June 20, 2017

**Re: McMahon Property Temporary Mass Grading  
Erosion and Sediment Control Plan  
Engineer's Stamp Date 6-16-17 (A11E016)**

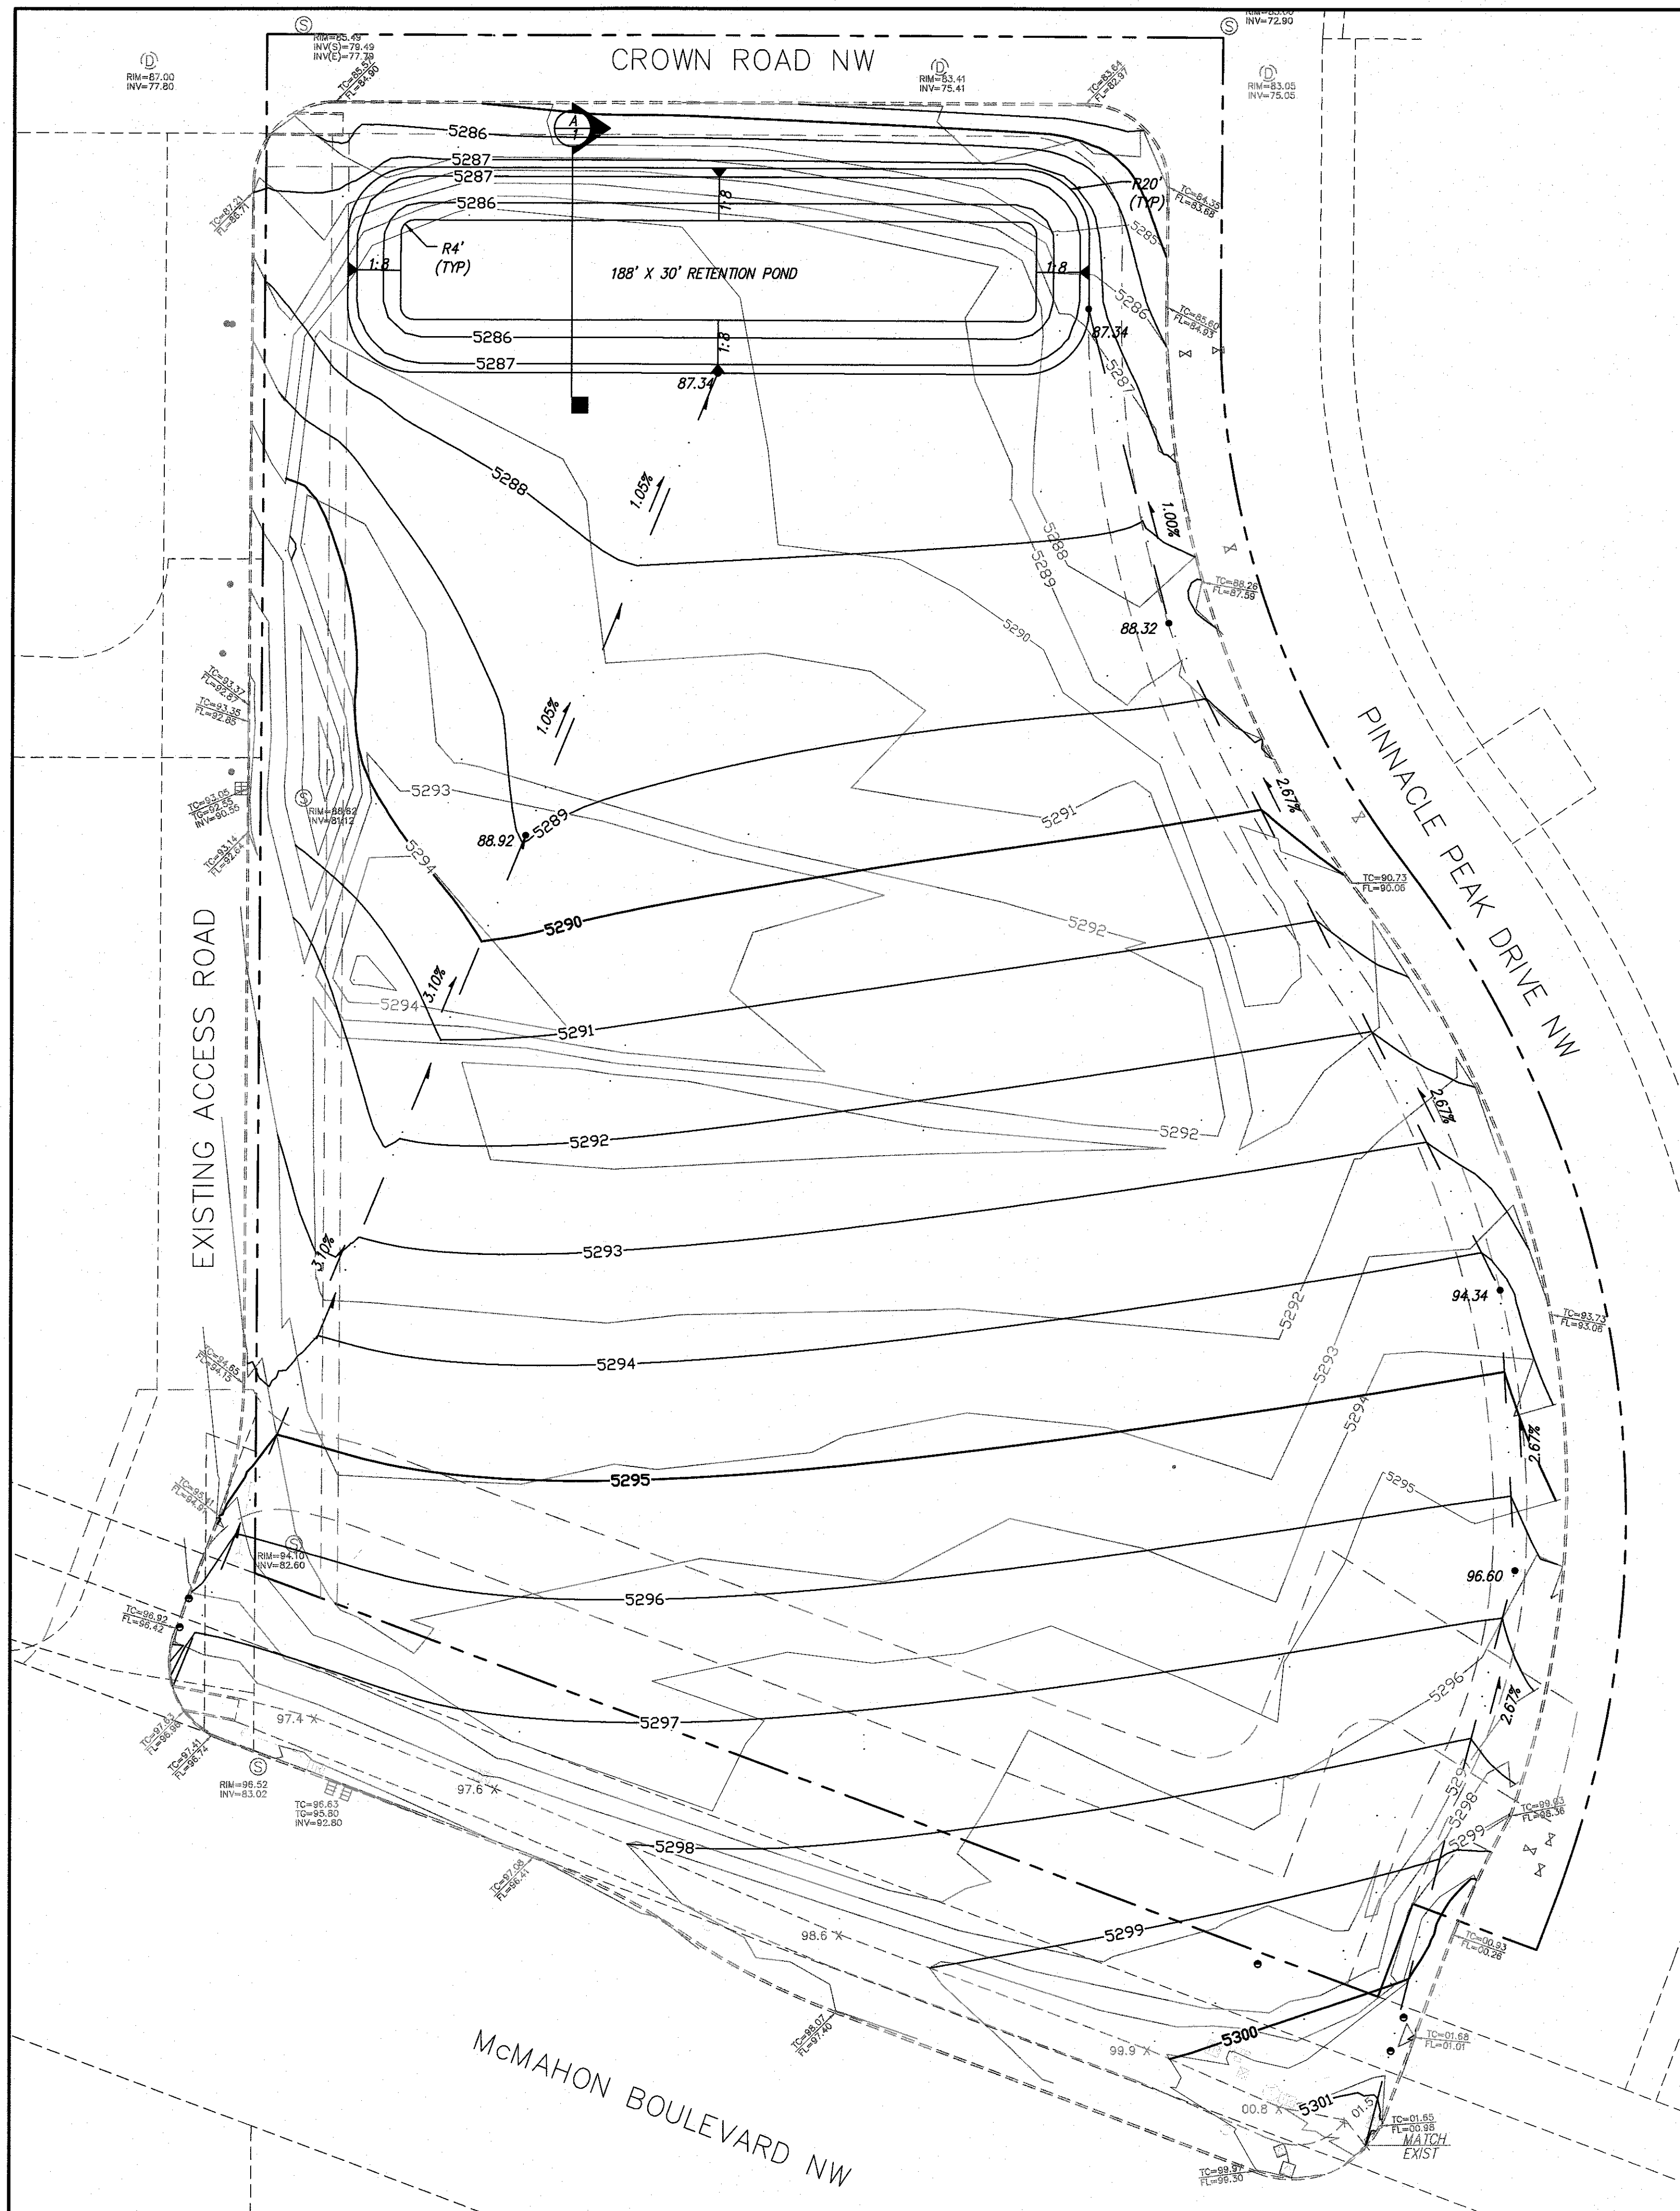
1. The silt fence poles are to be spaced a maximum of 10 feet apart on the straight runs with closer pole spacing (depends on radius) around the corners on the downhill side.

Please revise detail for future submittals.
